Two storey rear extension, recessed second floor extension, landscape works & retention of two storey containers & hoarding.

La Casa 57 Coastal Road Kingston

Thank you for your internet comments made on 17th May 2018 which has been recorded as **'an objection'** with the comments as follows:

Kingston Parish Council objects to this application for the following reasons:

Roof Plan as proposed

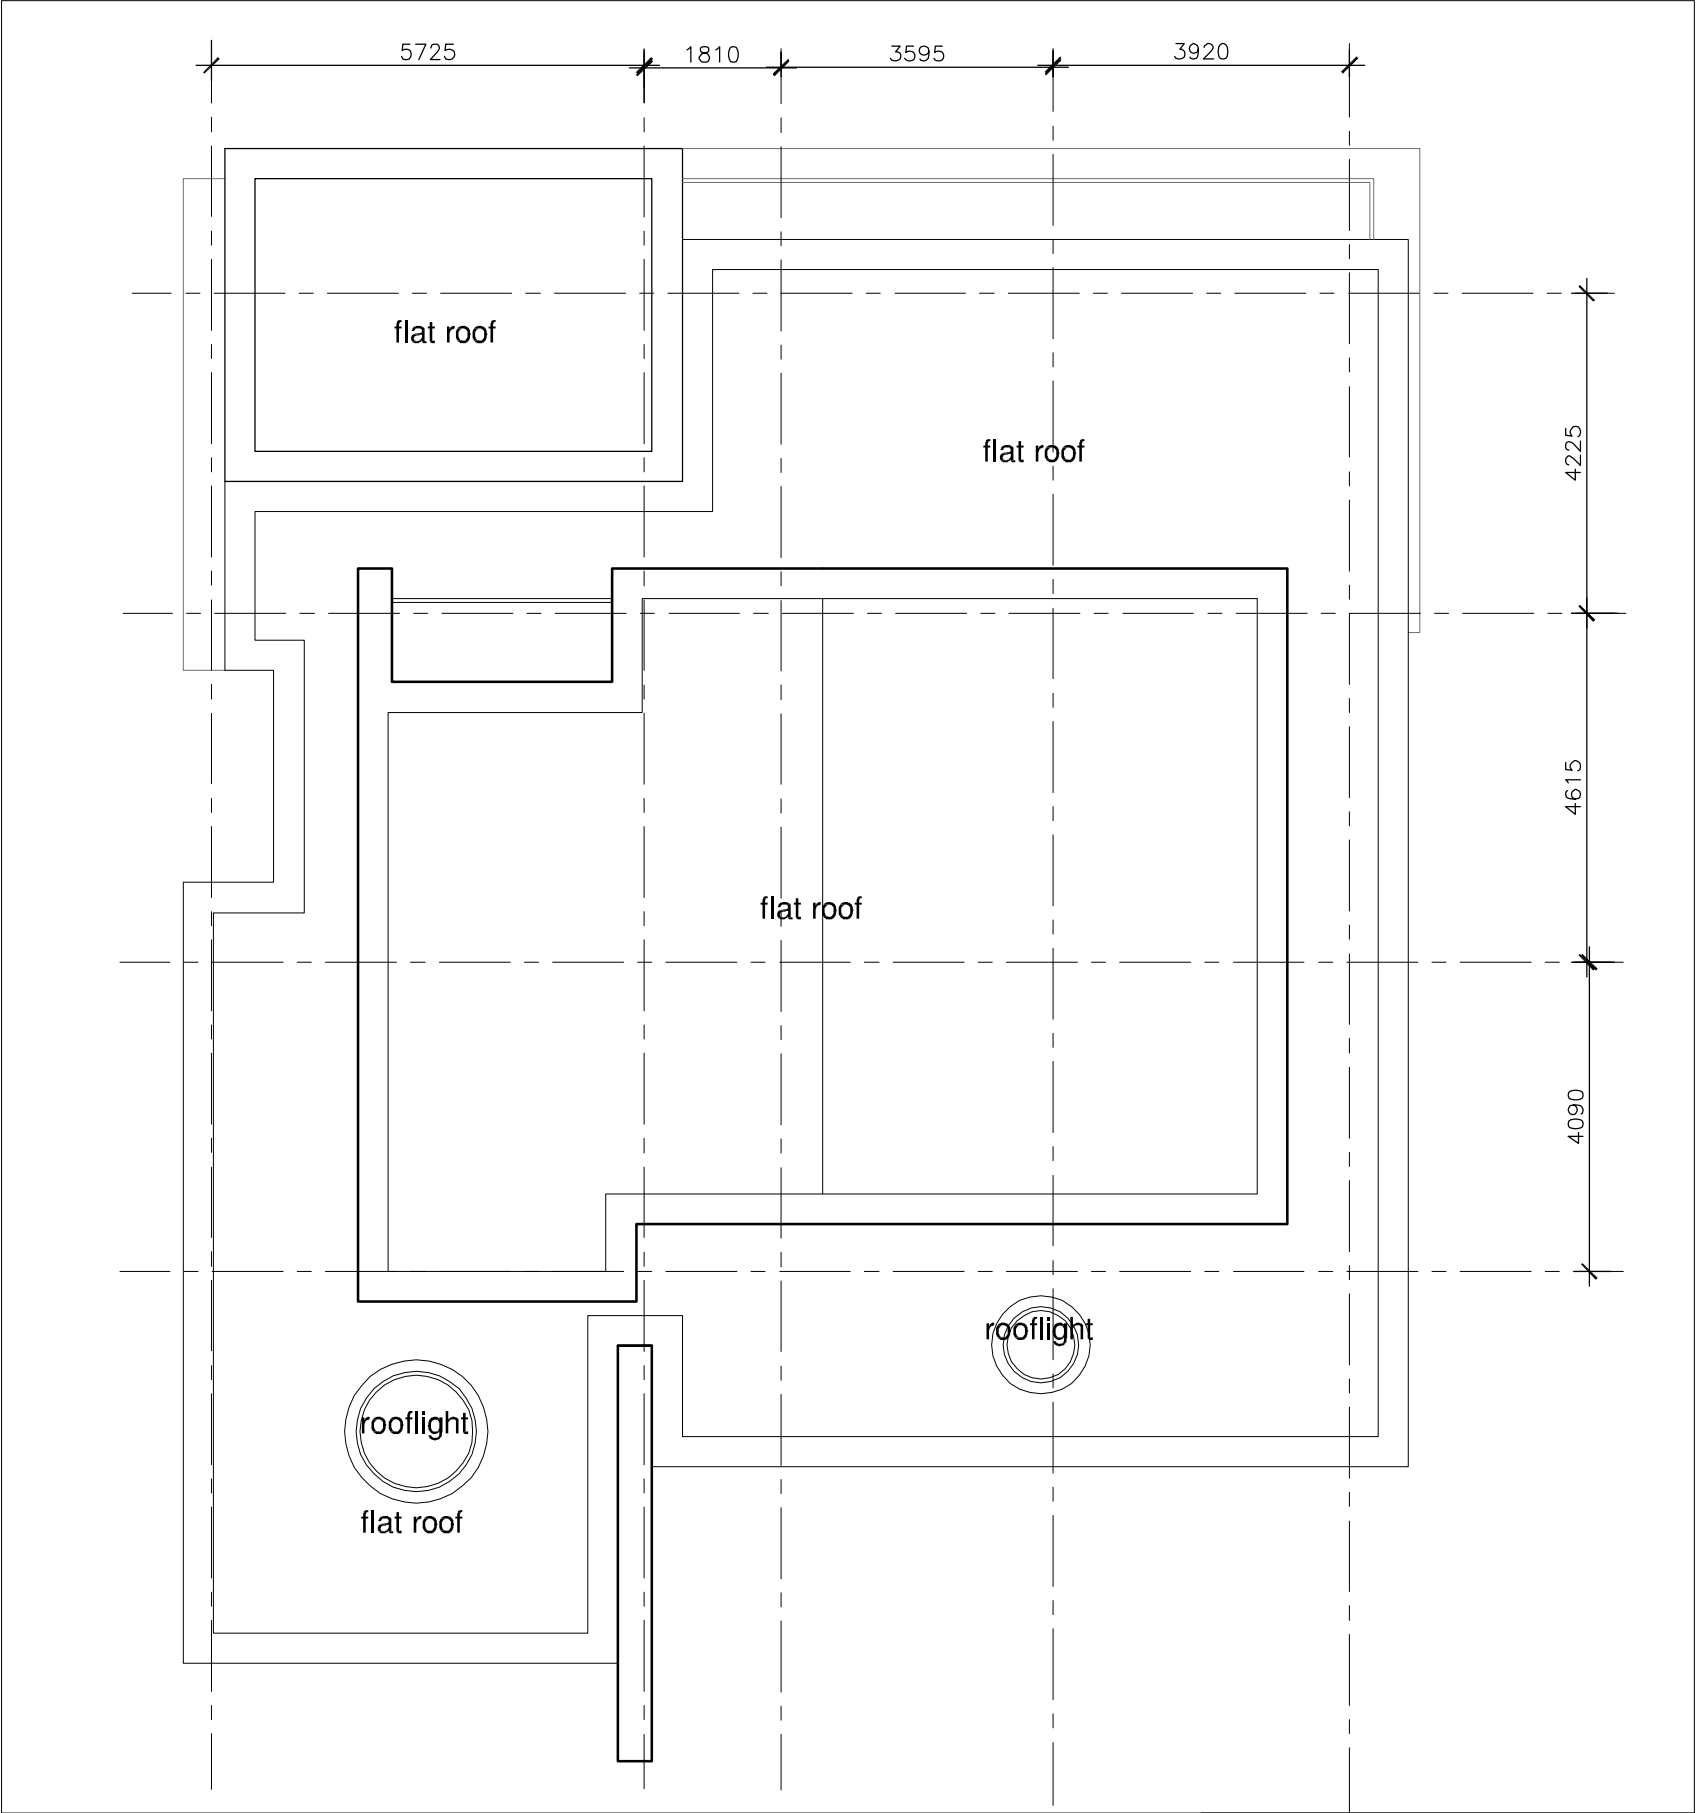
- 1. The proposed development by reason of its increase in scale, width, height, bulk and design will constitute overdevelopment of the site. This includes a rise in roof height and shape to create a 3-storey dwelling with a 2-storey extension to the rear.*

- 4. For the reasons given in point 1, the proposed development will be overbearing on neighbouring properties.*
- 5. There will be a loss of privacy for neighbours, all windows or glass to the east and west elevations above ground floor level should be opaque to prevent overlooking, and windows should be non-opening. Balconies should have privacy screens fitted to the east and west. There should be a condition that there is no access onto any of the flat roof spaces (except for maintenance).*

Site Plan as proposed

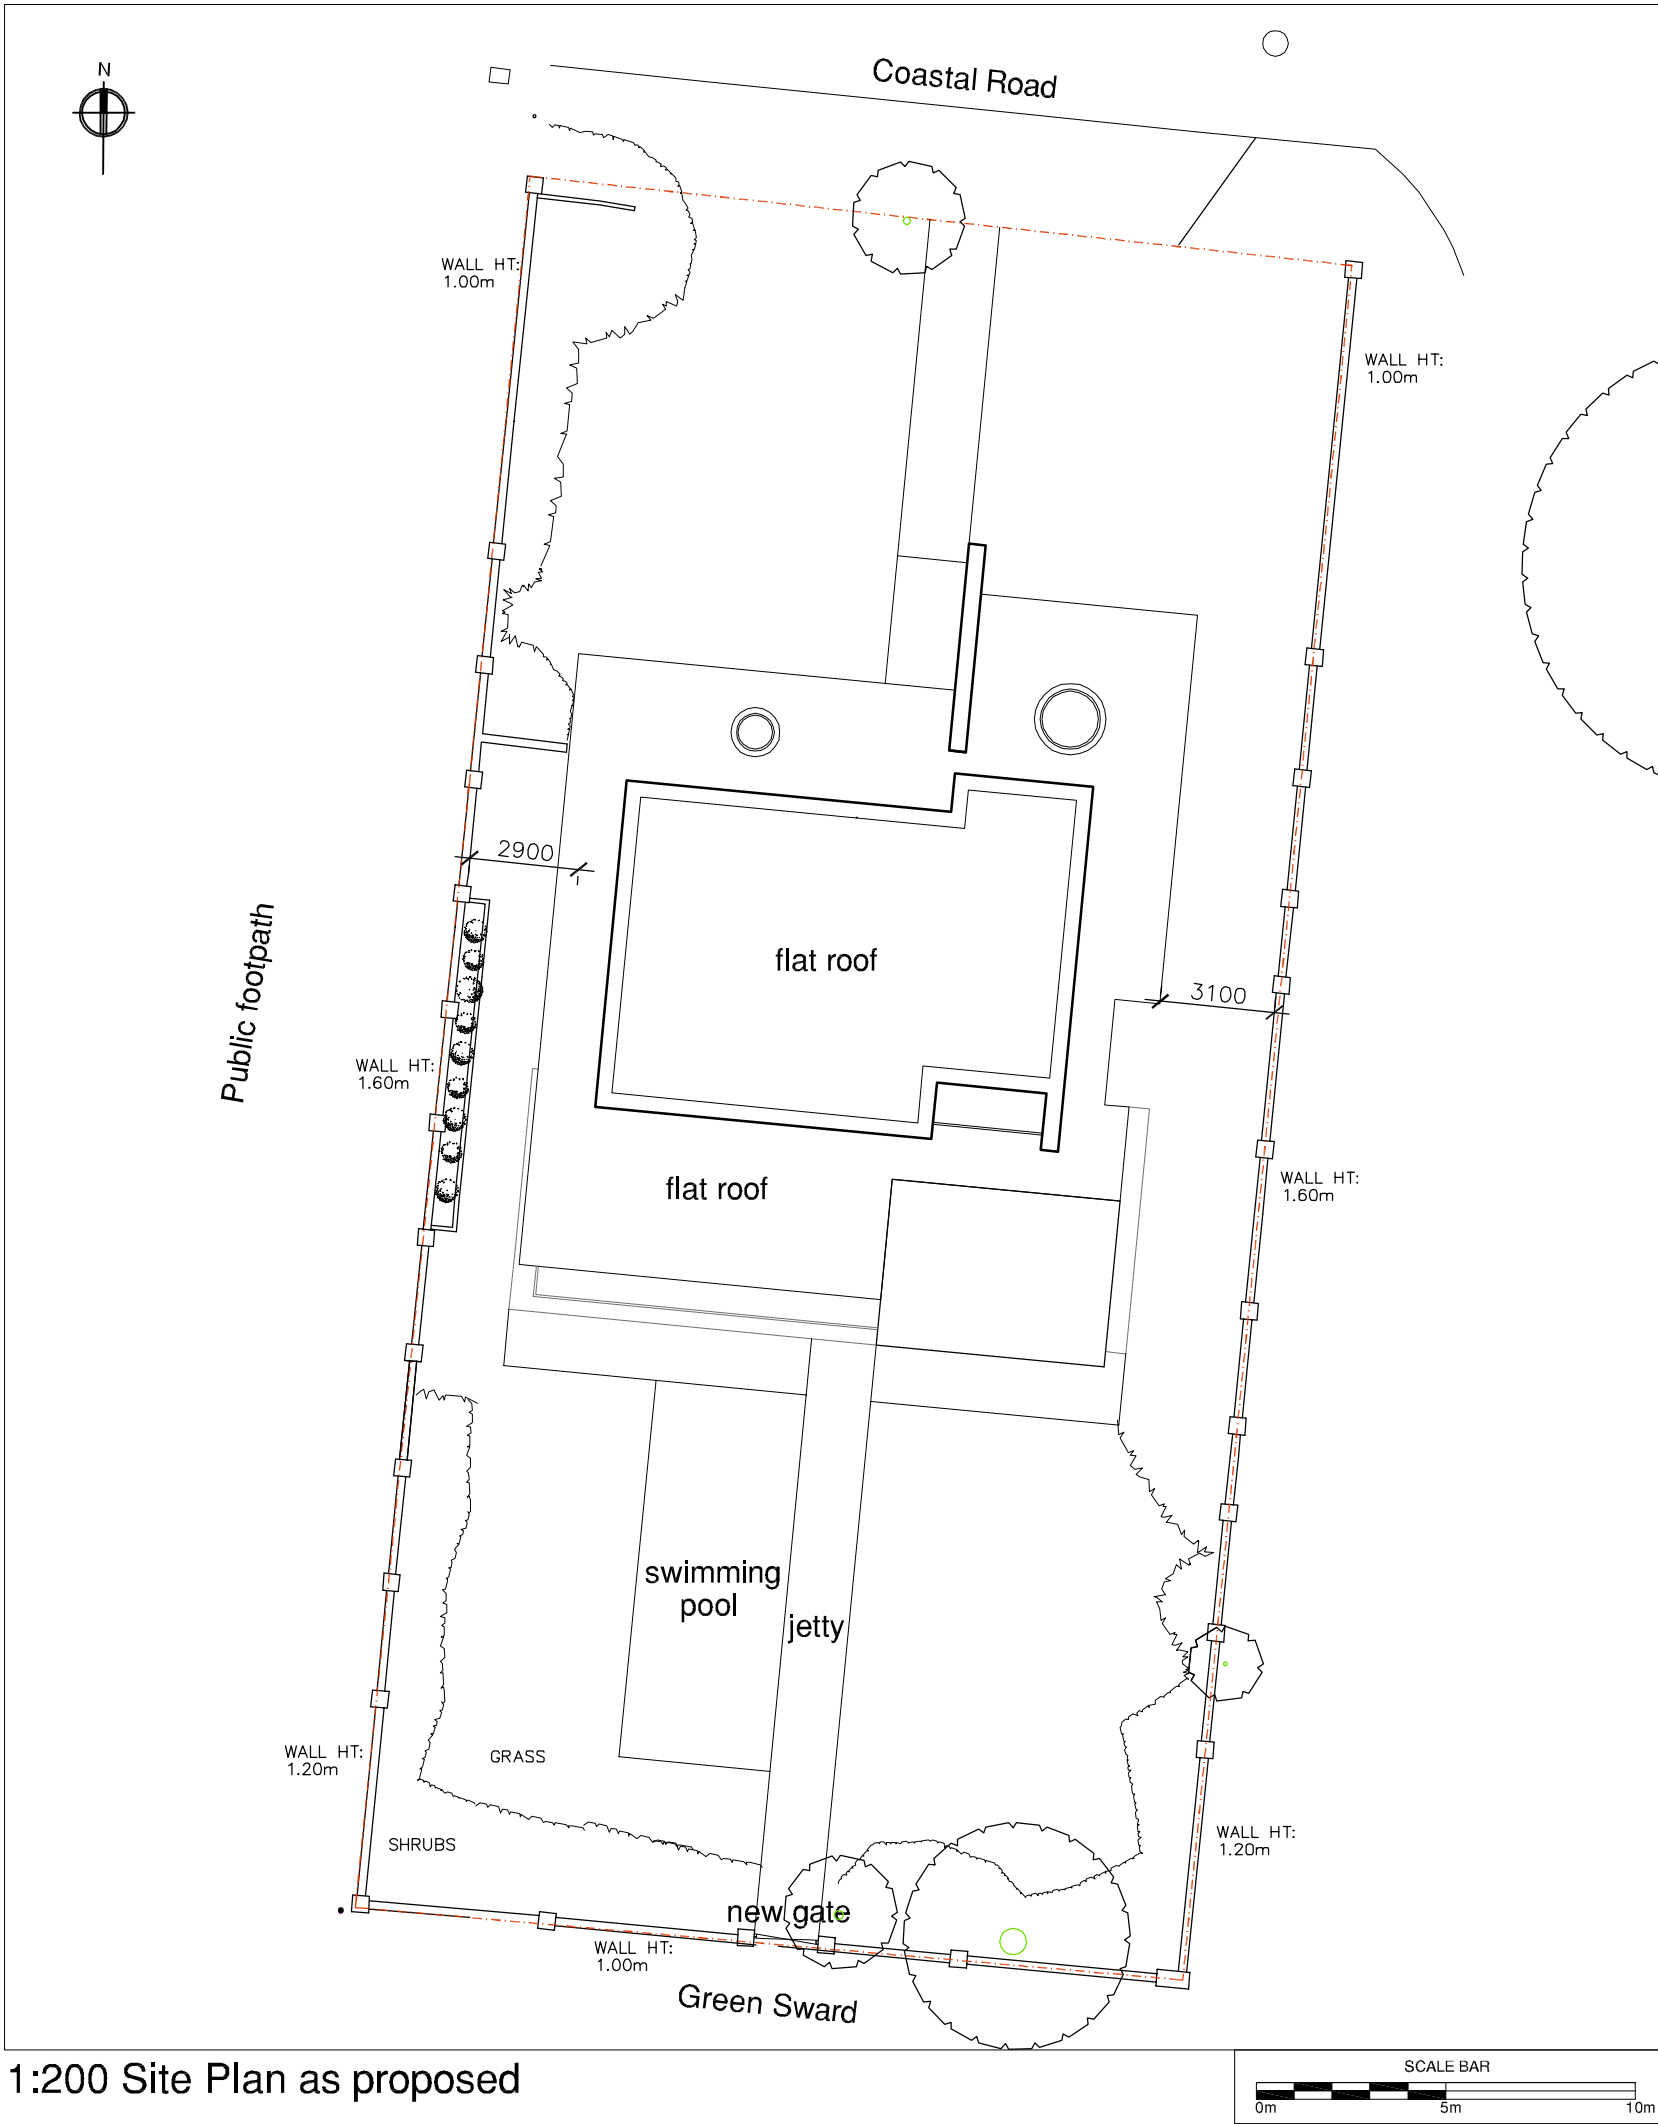
- 6. There will be a severe loss of light to the neighbouring property to the east.*
- 7. The property will now have 7 bedrooms and Council considers there is insufficient off-street parking provided for the potential number of occupants (14 adults). There is no on-*

street parking available nearby due to Coastal Road being a private road.

Given the proximity of the proposed development to the roundabout at the junction of Golden Avenue/Coastal Road/Golden Acre (where four sections of road meet) it will be hazardous if vehicles are having to reverse on or off the driveway: both for those reversing and those using the roundabout or travelling along Coastal Road. Therefore, there should also be space allocated for vehicles to turn around on site.

8. The two 2-storey containers in the front garden of the property are extremely damaging to the visual amenity of the street scene and should be removed. Any replacement containers should be single storey and only on site for a clearly restricted time period (e.g. 6 months).
